Observations By:	KC, Lead Local Flood Authority
------------------	-----------------------------------

Application No.	2023/93704
Proposed Development:	Erection of 12 dwellings and associated works
Location:	land northwest of, Urban Terrace, Denby Lane, Grange Moor, Huddersfield, WF4 4EB
OS Map Reference	SE 422319.5539 416203.7912
Applicant/Agent:	Broadgrove Planning & Development Ltd
Class:	Small Major Developments

Consultation Response from KC, Lead Local Flood Authority
2023/93704 land northwest of, Urban Terrace, Denby Lane, Grange Moor, Huddersfield, WF4 4EB
Erection of 12 dwellings and associated works
Date Responded: 22nd October 2024 Responding Officer: Paul Farndale Responding Ref:

Kirklees Flood Management & Drainage continues to OBJECT to this application.

1 Proposed Site Layout

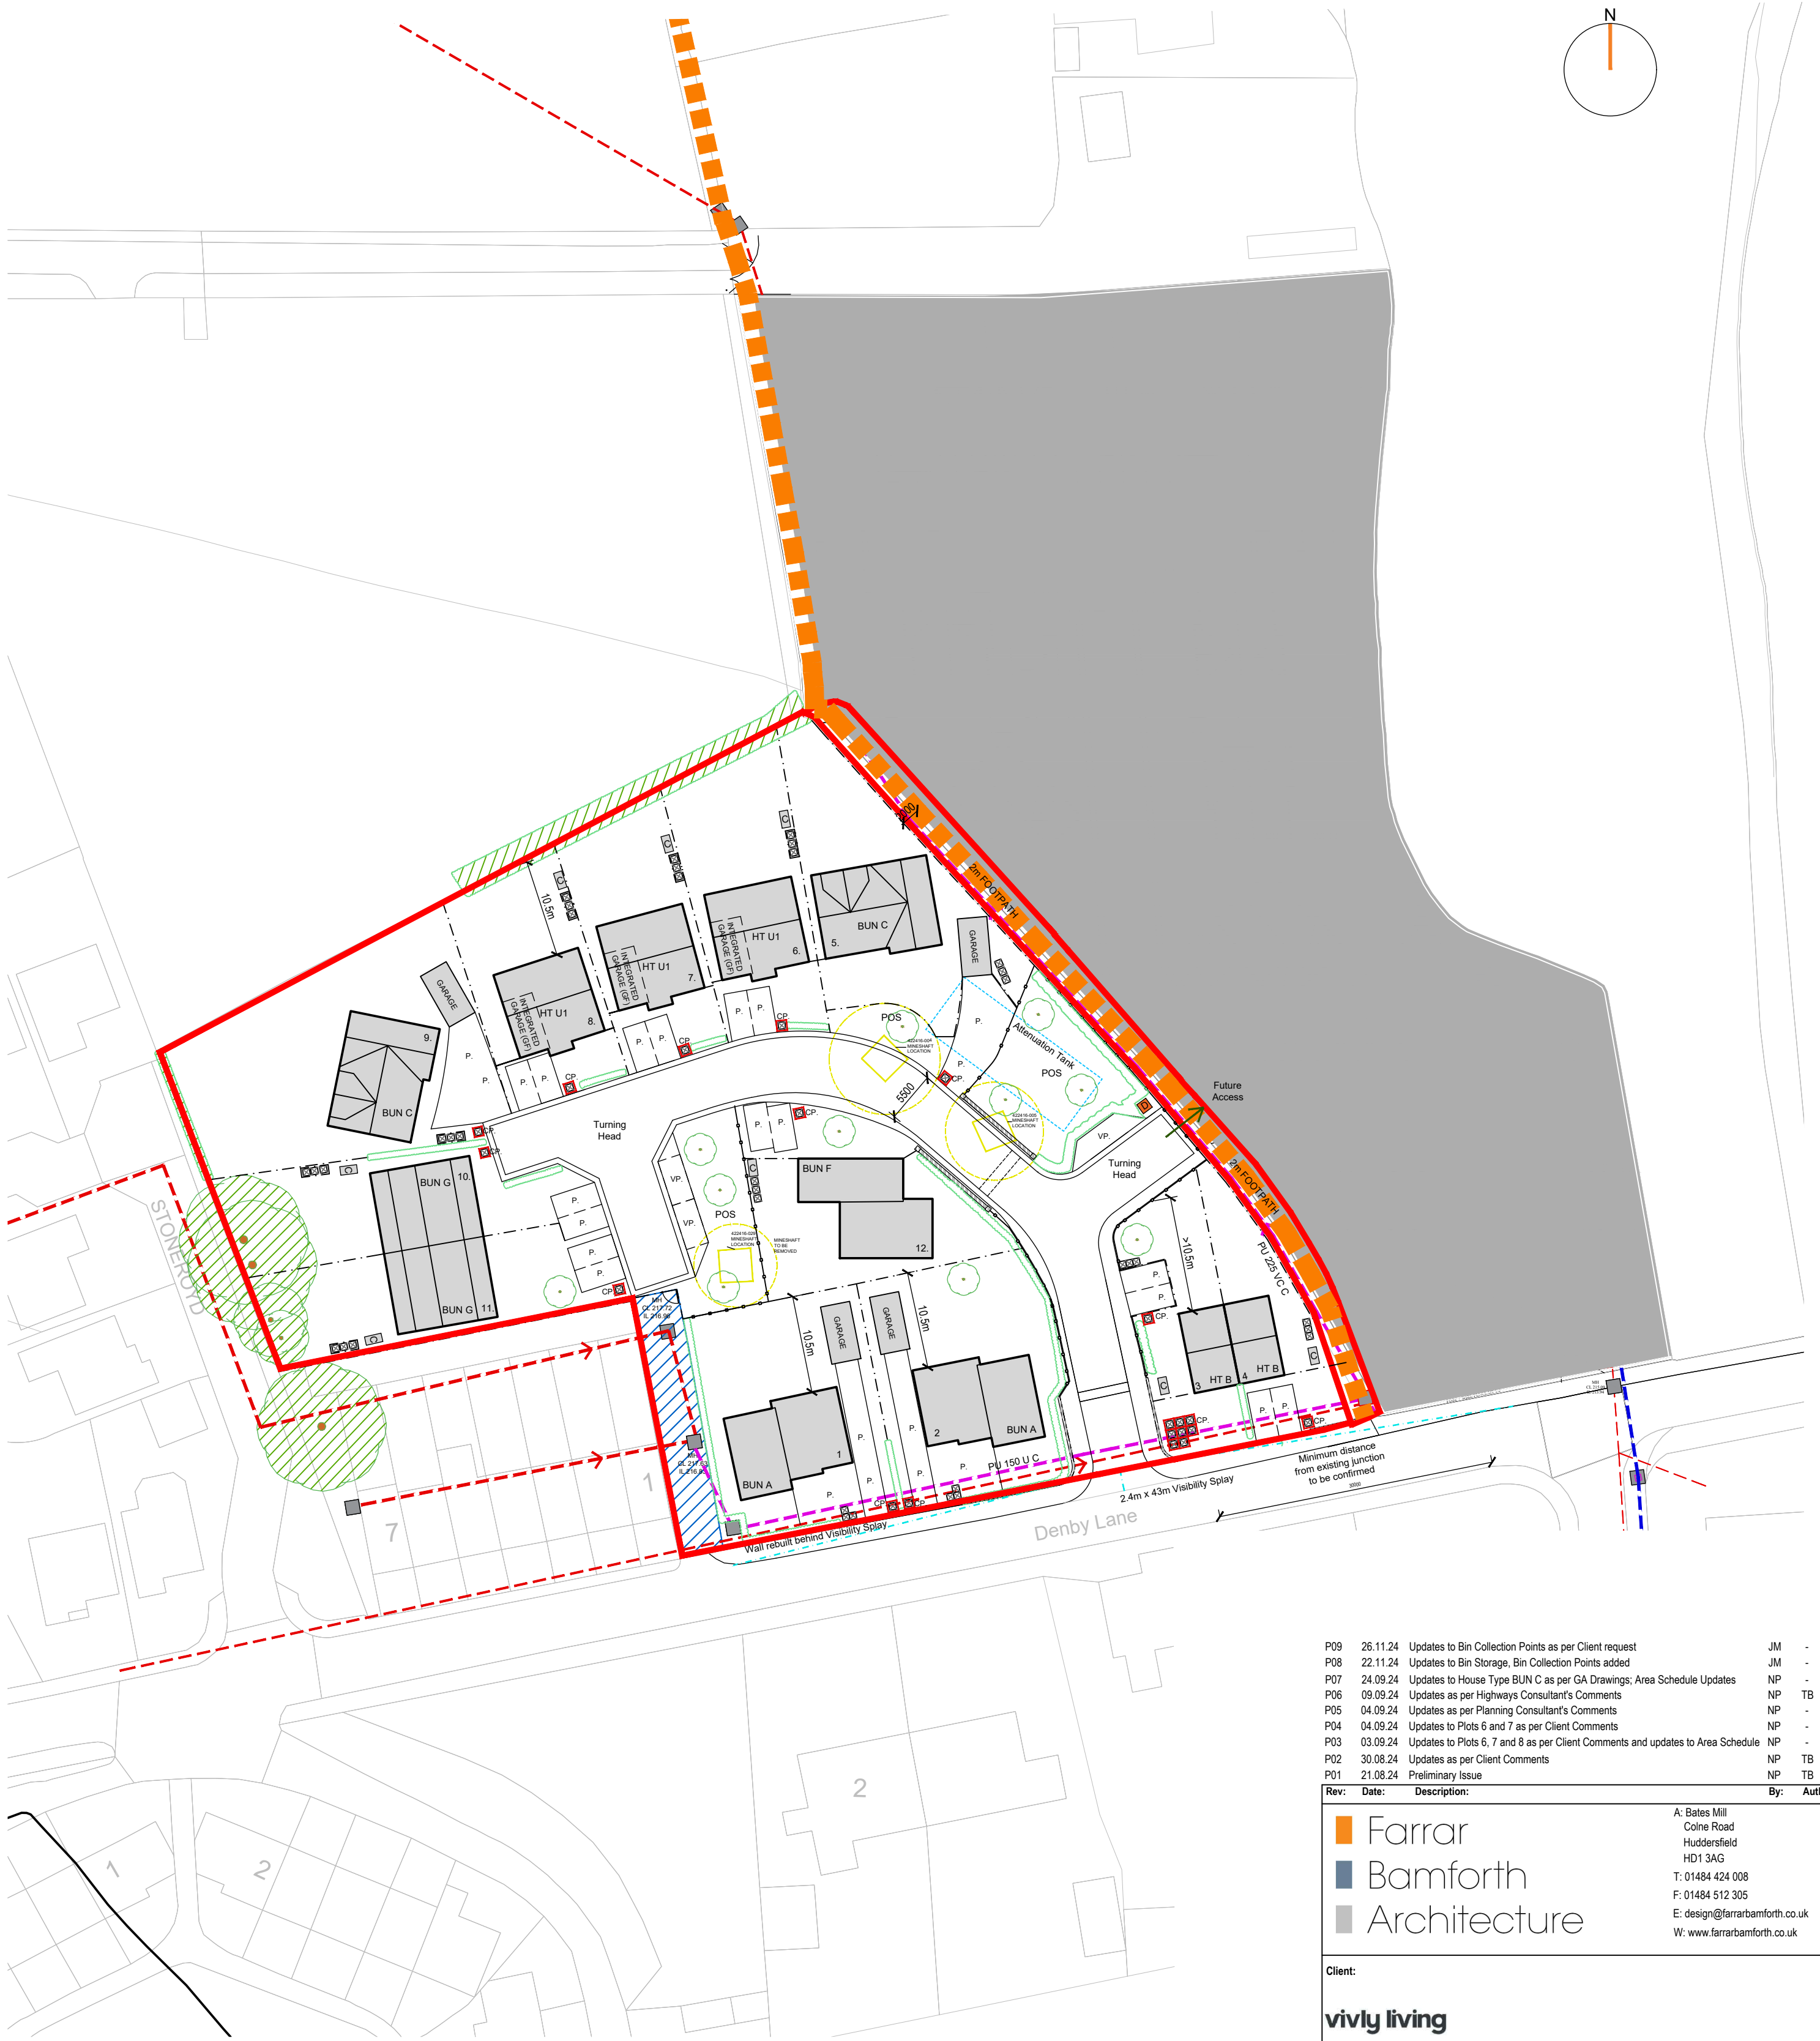
Although the LLFA doesn't normally assess gully spacing as this is a highways matter, it appears that not all the roads shown on the layout plan are drained.
